Letter of Intent

Sam Thomas & Associates
975 Tercel Dr.
Peyton, CO 80831
Project Name: Big O Tires

Requesting to plat existing lot (currently metes and bounds) to make a legal parcel.

LARGENT SUBDIVISION

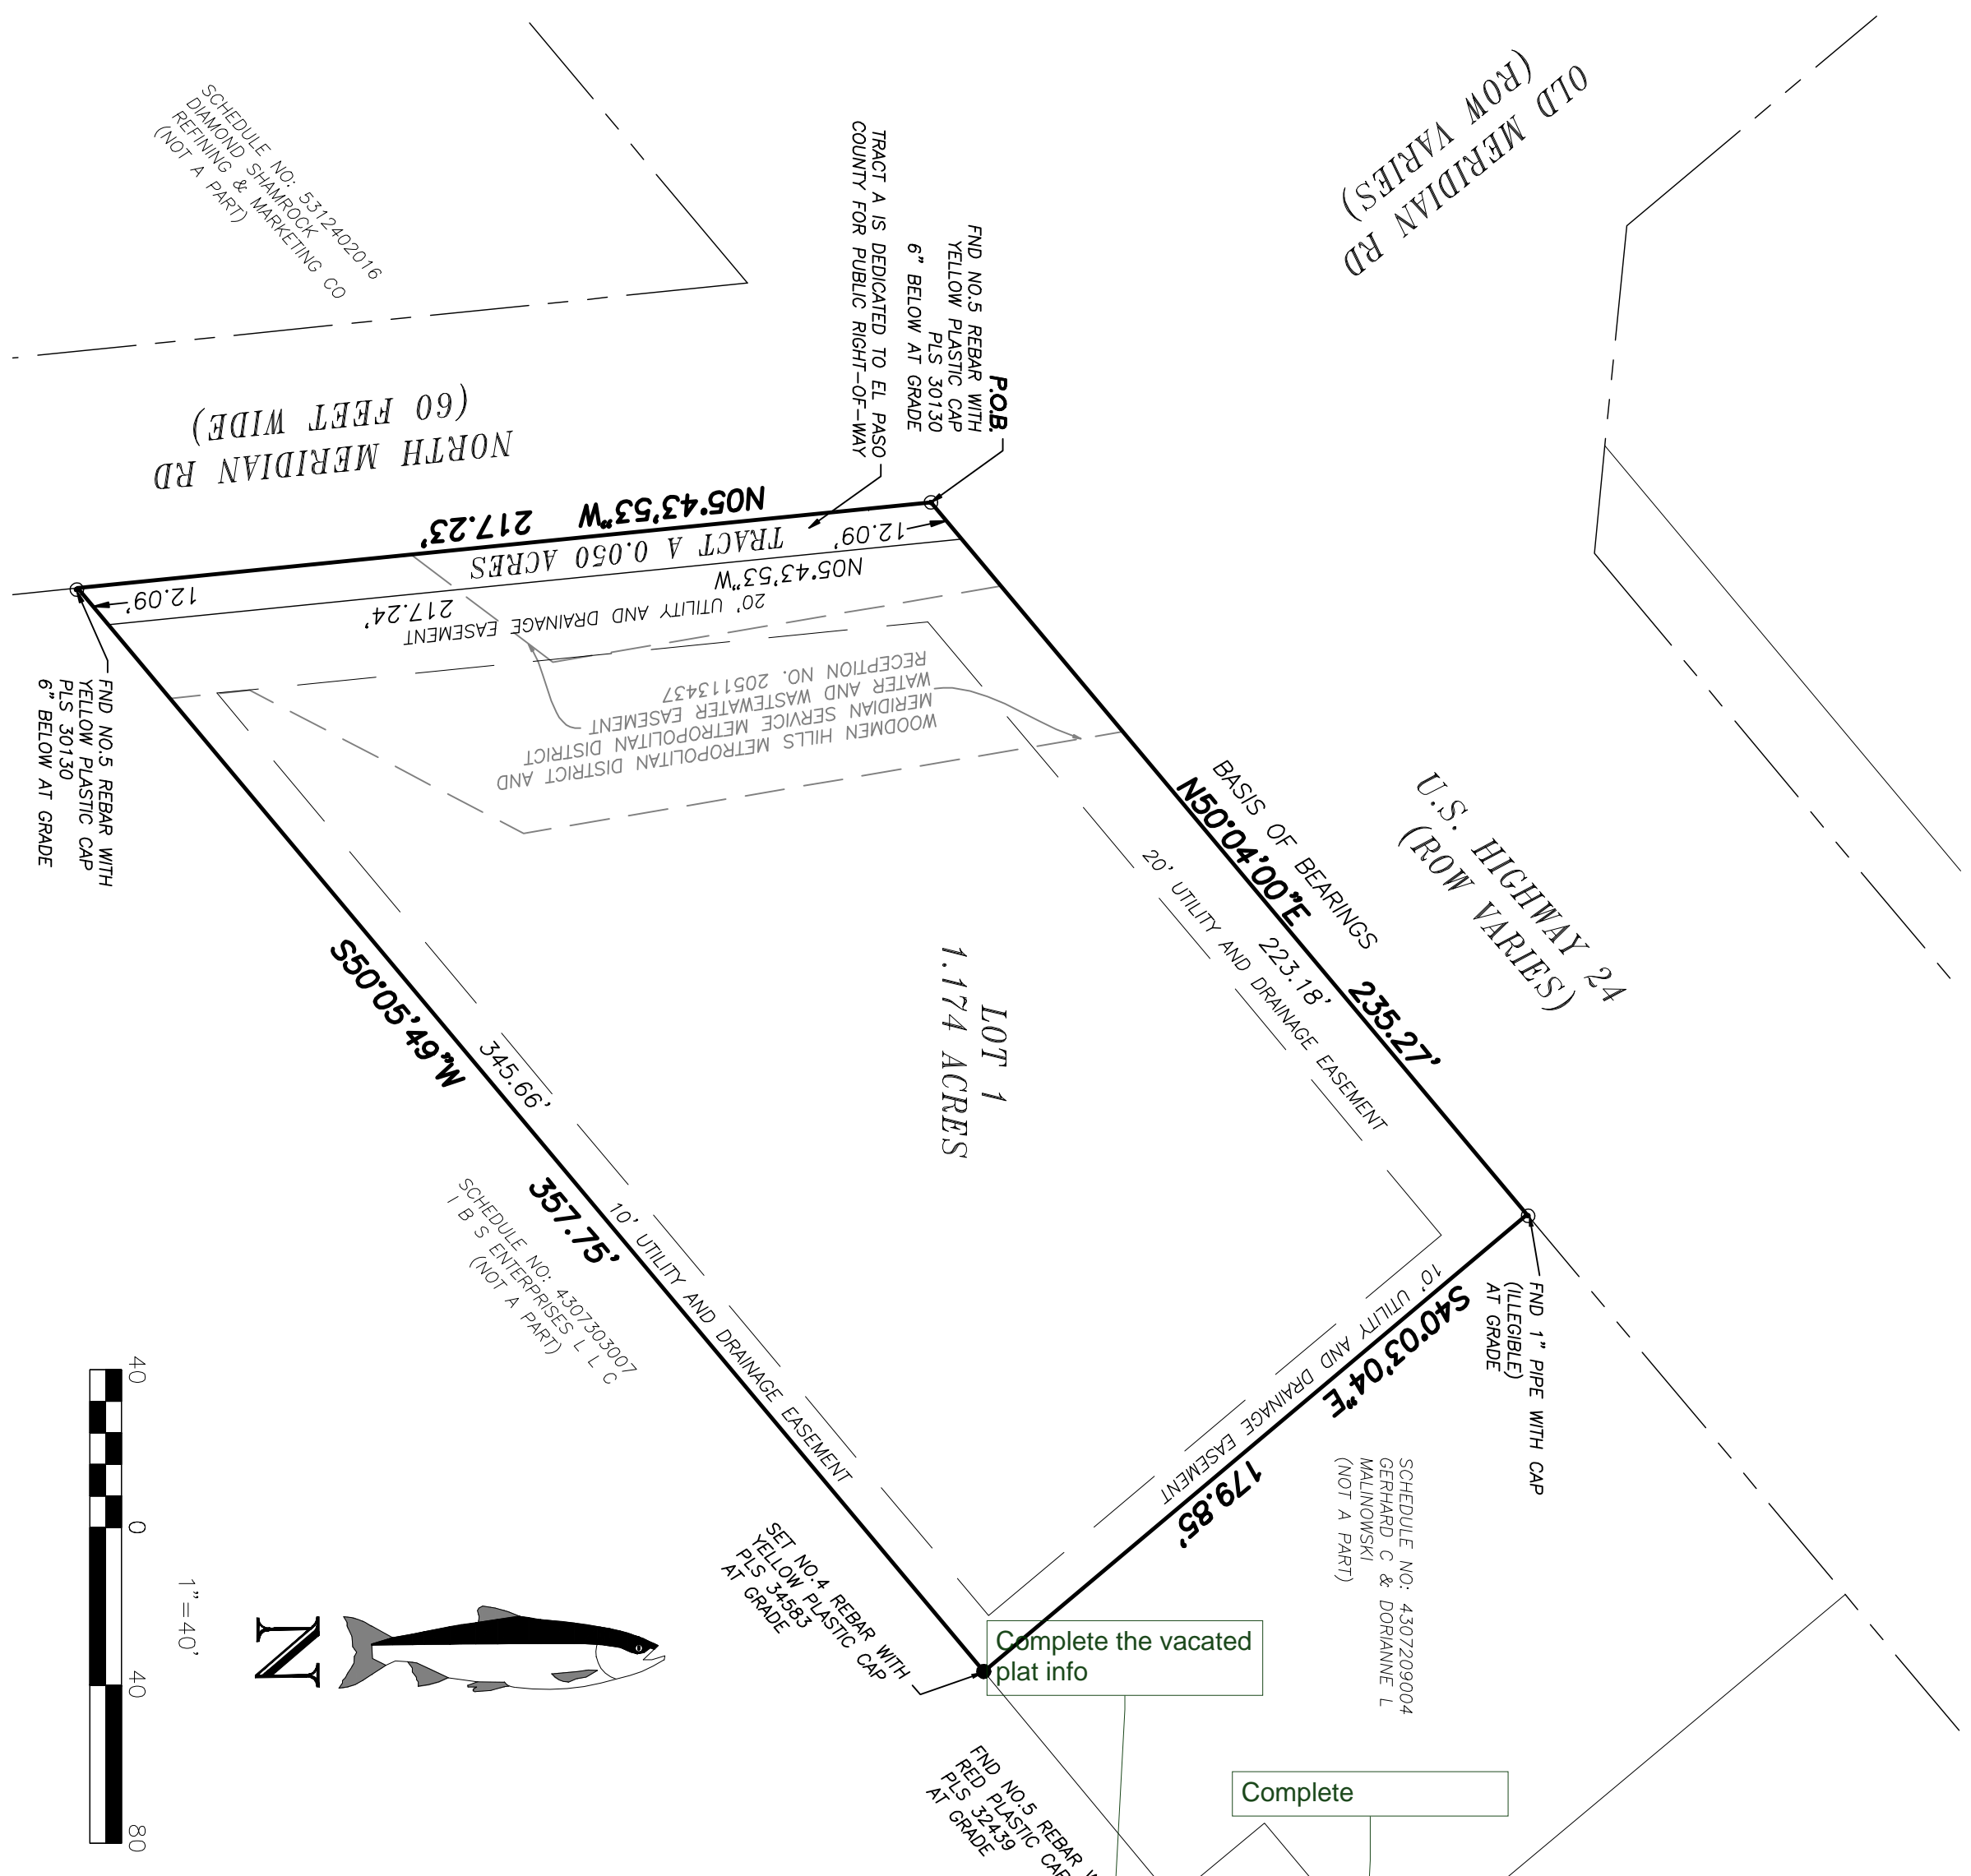
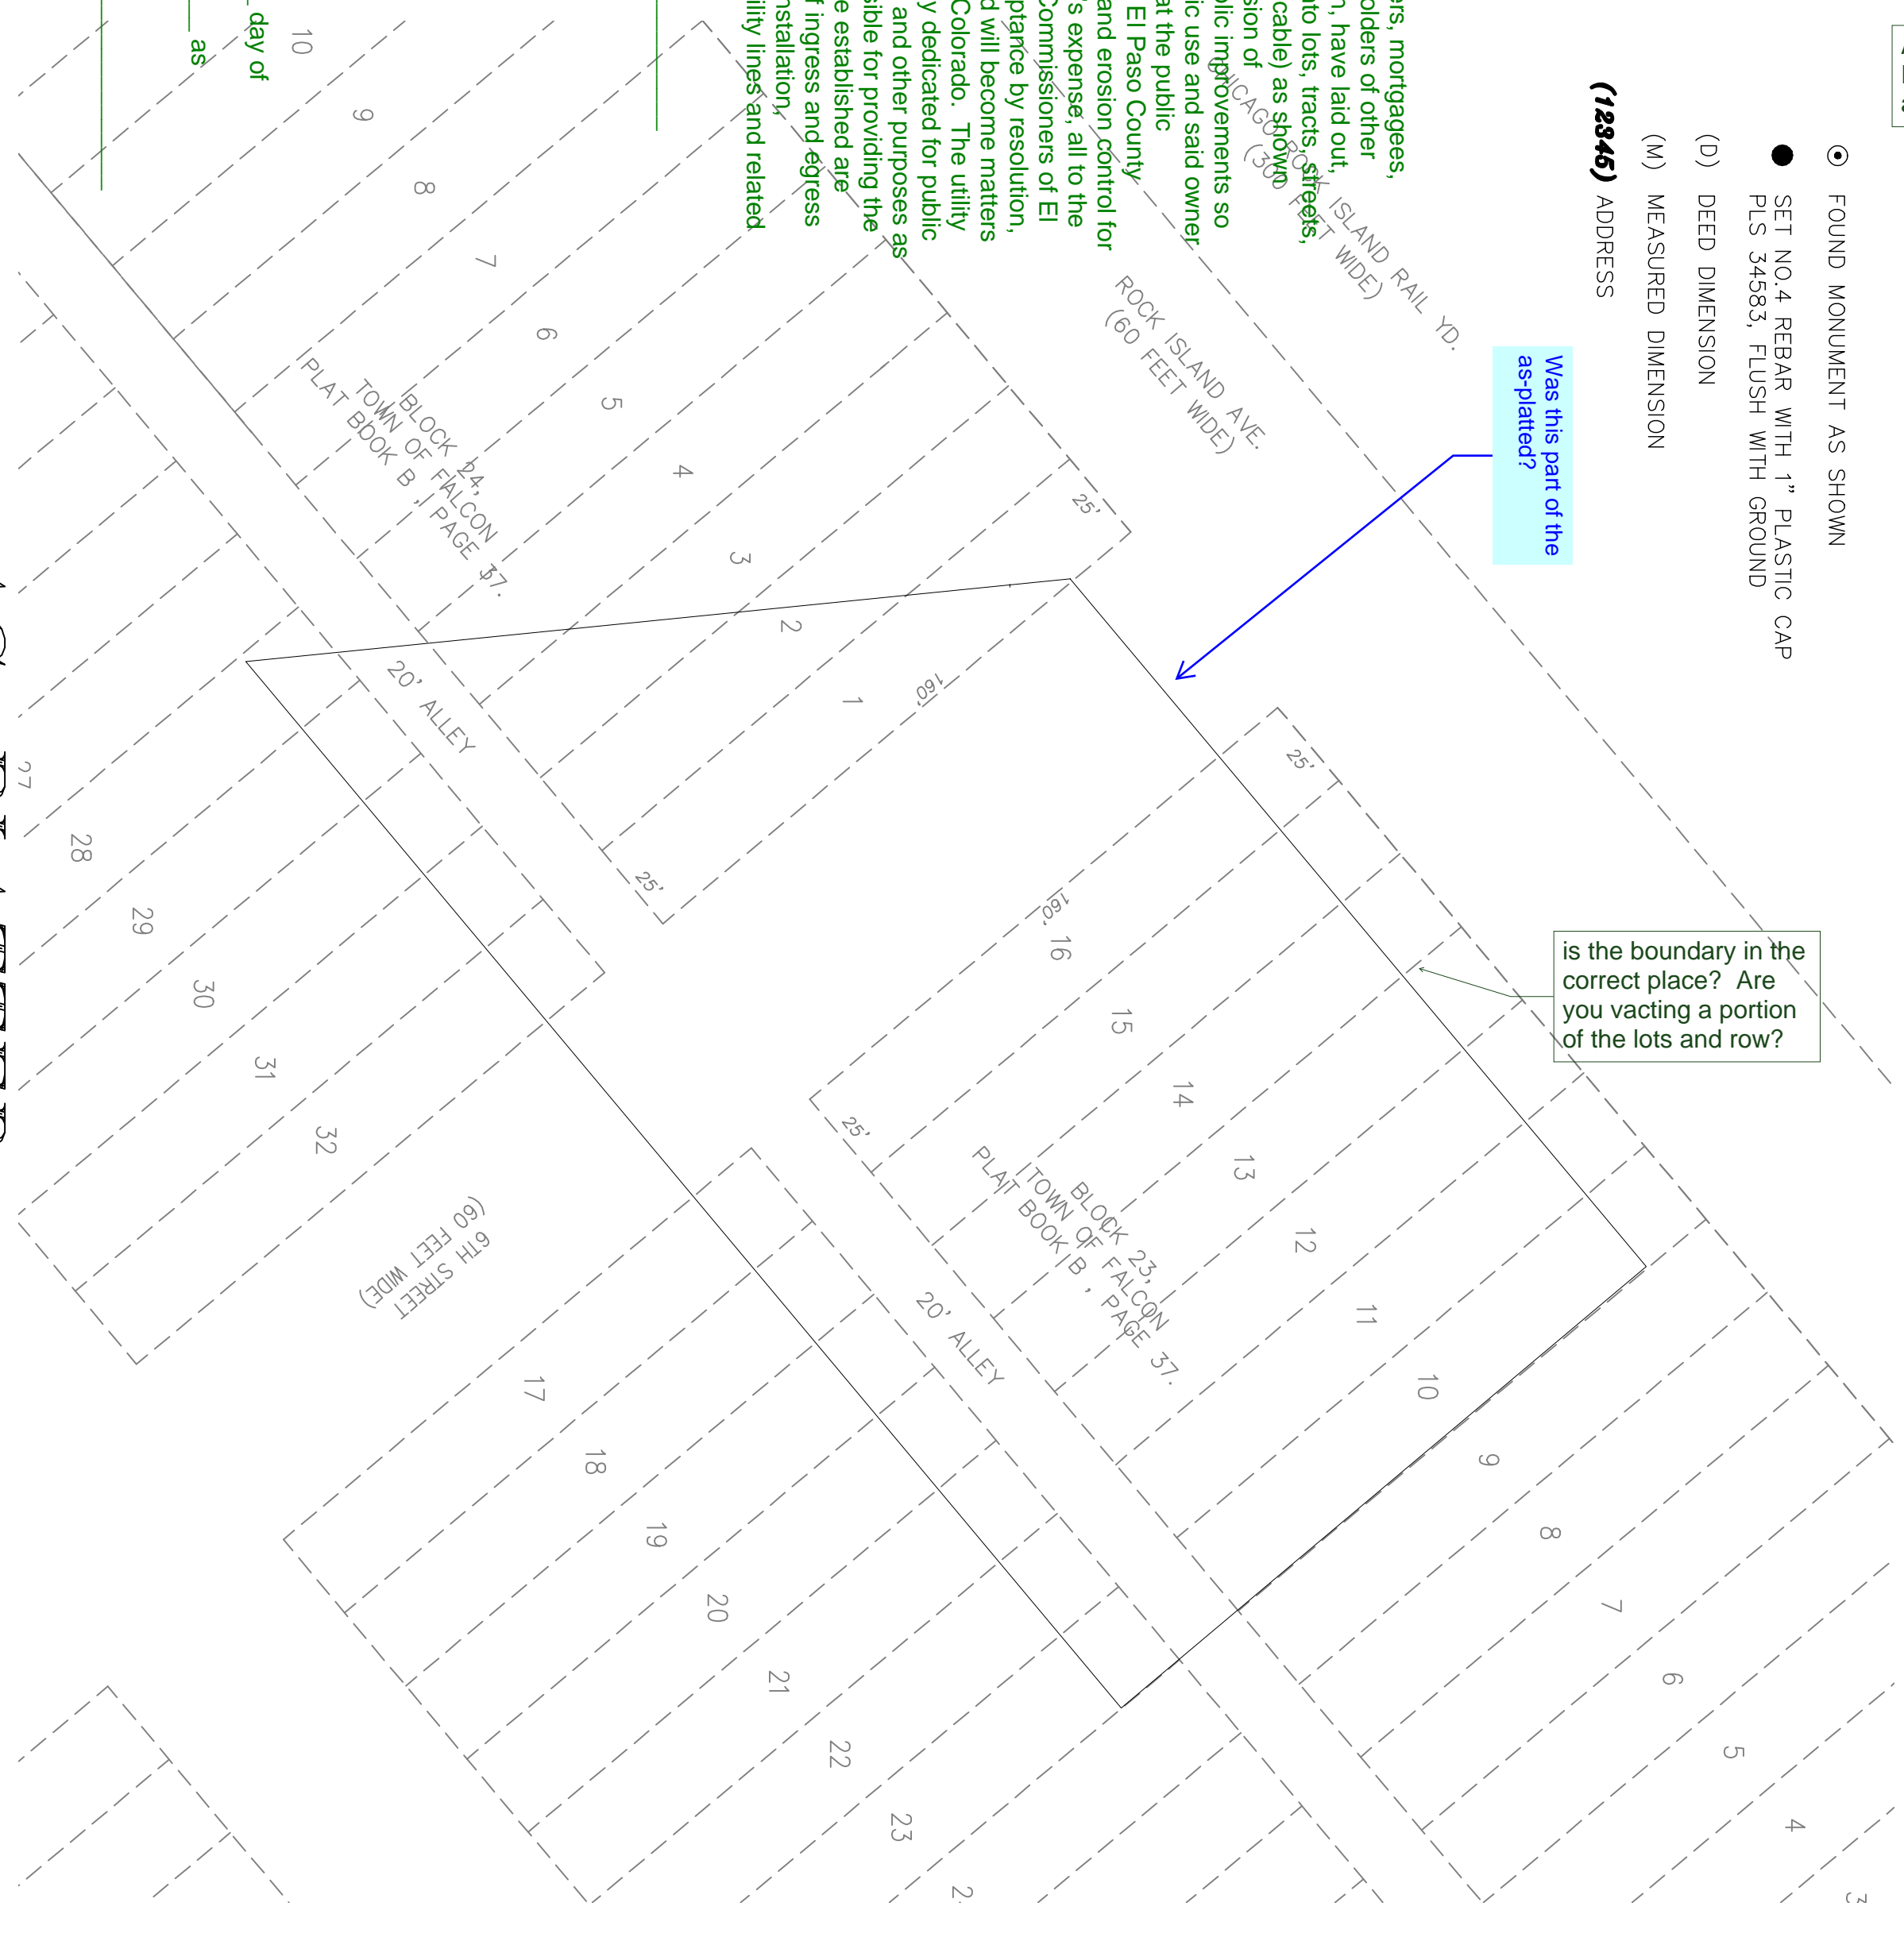
This is a parcel not a lot; you requesting to create a legal lot

Address criteria for the Replat approval 7.2.3 page 7-27. You may need to provide history as it pertains to the zoning condition of approval requiring the parcel be platted to meet the criteria. Address the Approval criteria for a Plat approval as referenced in the above criteria. The Board must make it at the hearing and you have not discussed it (7.2.1.) page 7-9.
